**Consultation Response from KC,
Lead Local Flood Authority**

2026/91721 land at, Greenhill Bank Road, New Mill, Holmfirth, HD9 1ER

**Discharge of details reserved by condition 18 (drainage) on previous permission 2023/90346 for
erection of two detached dwellings**

Discharge of Drainage Conditions

Drainage Layout

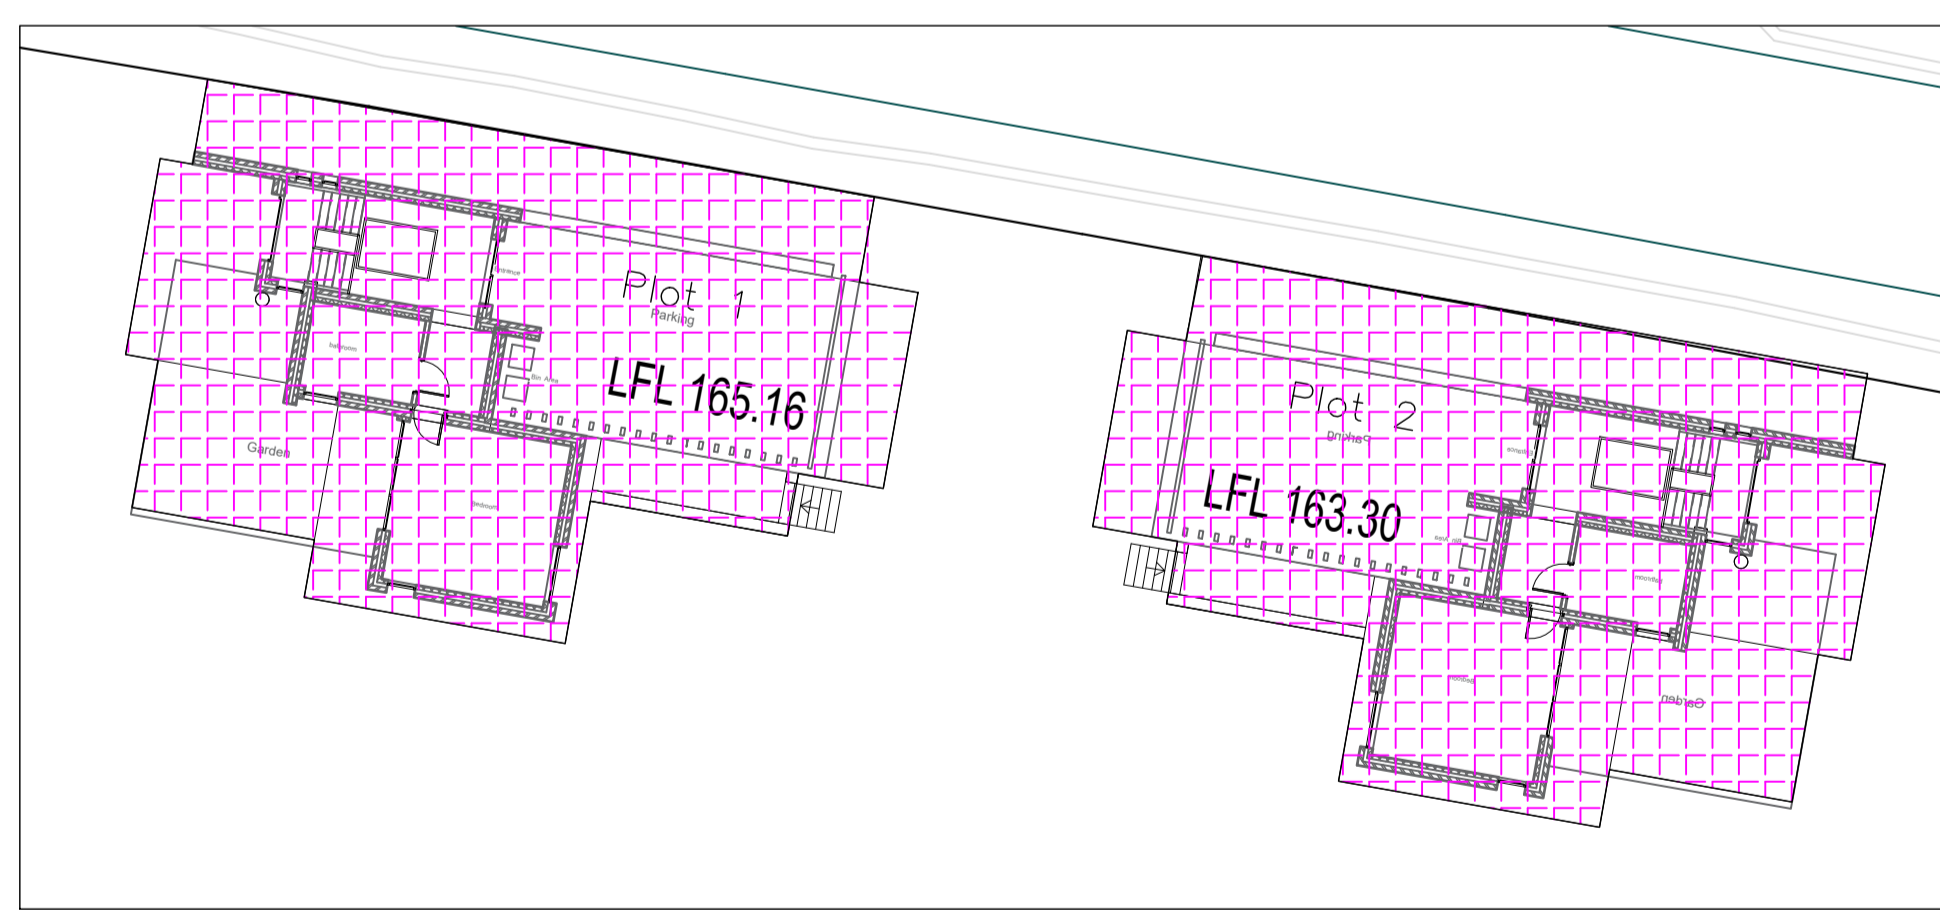
The LLFA confirms that the revised Drainage Layout and the associated hydraulic calculations are accepted together with the proposed allowable surface water discharge rate of 3.0l/s and proposed outfall connection to the Yorkshire Water sewer outside No. 21 Greenbank Road (subject to YW approvals and permits).

Therefore, Condition 18 can be discharged.
